From: Anthony Monaghan
Sent: 04 November 2016 15:29
To: DCAdmin
Subject: FW: Poplar Farm - 2016/92041

From: Kevin Ellam
Sent: 04 November 2016 15:18
To: Anthony Monaghan
Subject: Poplar Farm - 2016/92041

Drawing Title
Drainage Plan

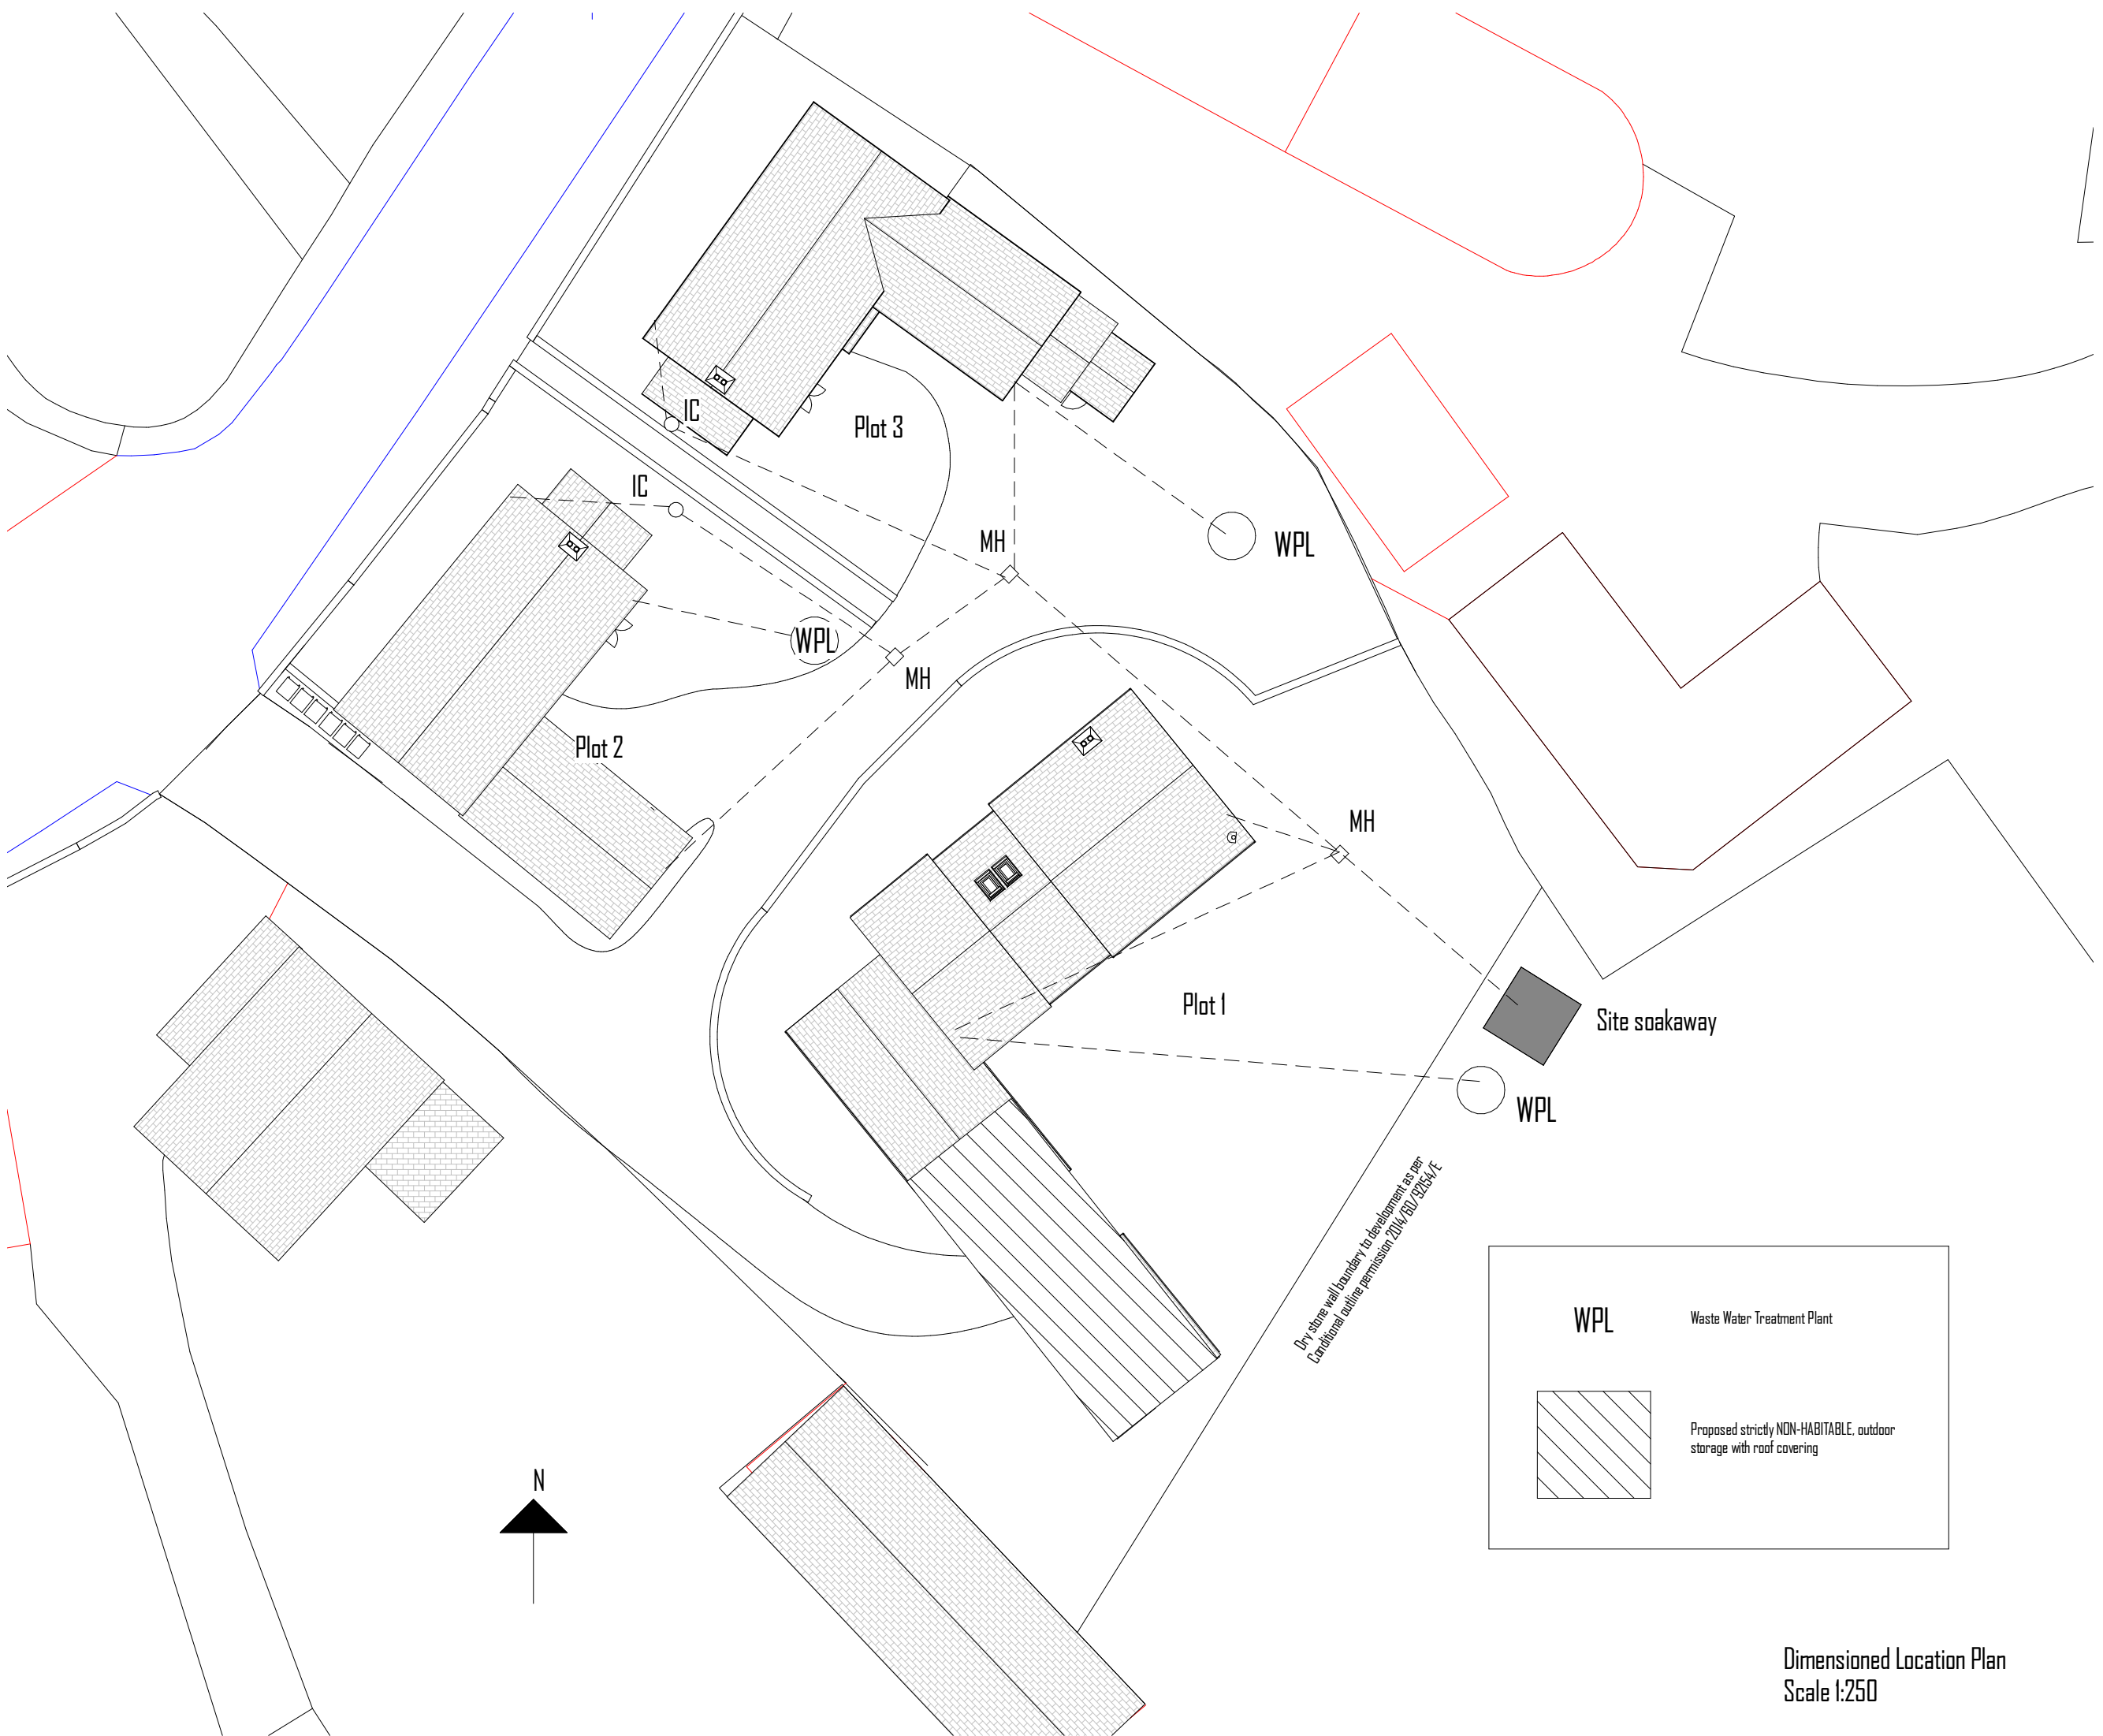
The above application suggested that they were going to connect to mains, which we would recommend in the first place.

If however this is not viable and they are going to put in a water treatment plant I would recommend the following condition:

I recommend that the applicant submits a report giving details of the packaged sewage treatment plant to be installed, & that it be agreed in writing with the LPA, before development commences. In particular the following information should be included:

- 1 Location of the tank. The site selected should not be so near to any inhabited building as to be liable to become a source of nuisance or a danger to health (a minimum of 15m is desirable. It is preferable if it is over 20m). It is essential that no well, stream or river etc is liable to be polluted. If the location is near any such source it is recommended that the Environment Agency be consulted about the application.

- 2 The capacity of the tank and number of persons using the tank.
- 3 Adequate means of vehicular access should be provided to allow the tank to be emptied.

- 4 Details of the necessary porosity and percolation tests carried out to establish suitability of land if to be used for soakaway/land drainage of effluent. It is important these tests are carried out before planning permission is granted. Failure to carry out the tests could result in permission for a development being granted when the land is incapable or not suitable for soakaway drainage. It is strongly recommended that no planning permission is granted for a development involving septic tank drainage unless these tests have been carried out and the land found to be satisfactory.

The installation shall be installed and maintained in accordance with the agreed details.
